From: PETER SHAW [REDACTED]
Sent: 27 May 2014 14:12
To: Charlotte Burrows
Subject: Re: Further Information Required on Your Ref: PP-03376778 Our Ref: M/37/14/HH
Attachments: 1588_01_03.pdf; 1588_01_04.pdf; 1588_01_05.pdf; 1588_01_07.pdf; 1588_01_09.pdf

Subject: RE: Further Information Required on Your Ref: PP-03376778 Our Ref: M/37/14/HH
Dear Mr Shaw,

Drawing: Ground floor as proposed	
For: Mr. & Mrs. Reeves	
Drawn: PKS	Date: May 2014
Scales: 1:50	No: 1588/01/03
To scale when printed on A3

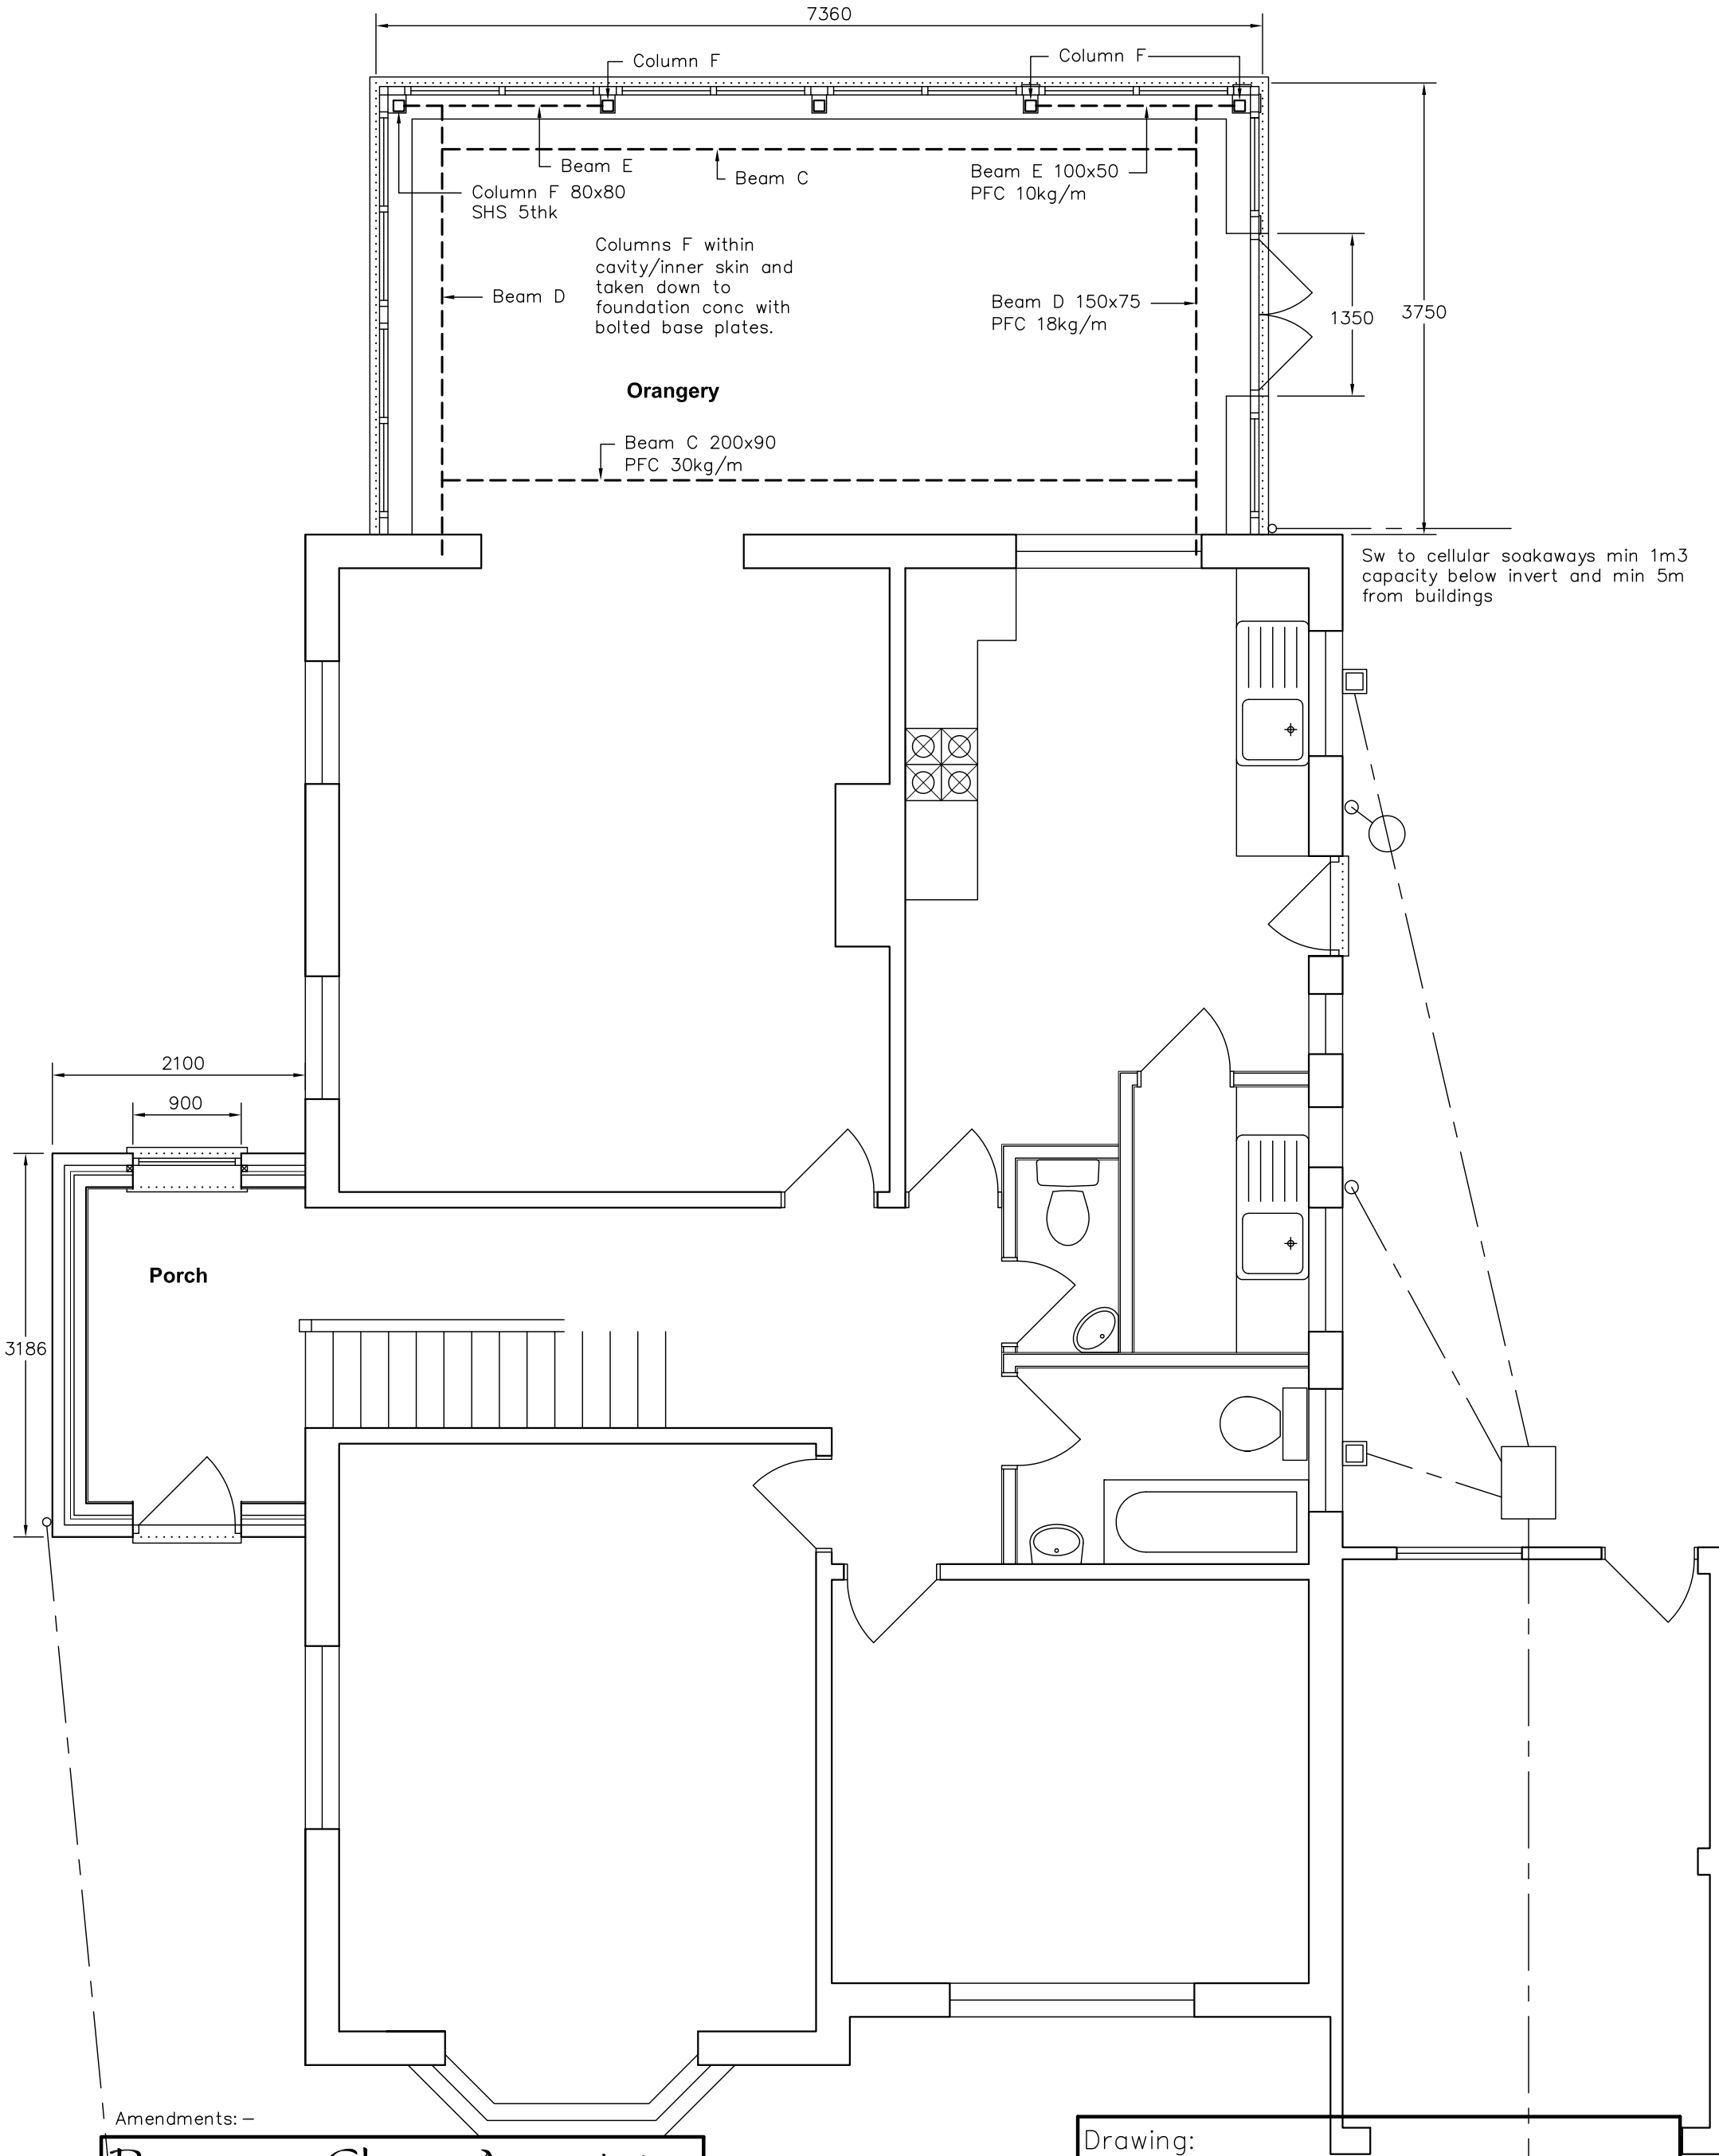
Thank you for the amended block plan. Please note I still require a revised proposed floor plan as there appears to be a window missing from the west side that has been indicated on the elevations & the Lidsey confirmation.

Amended drawings attached. Please substitute for the ones you have.
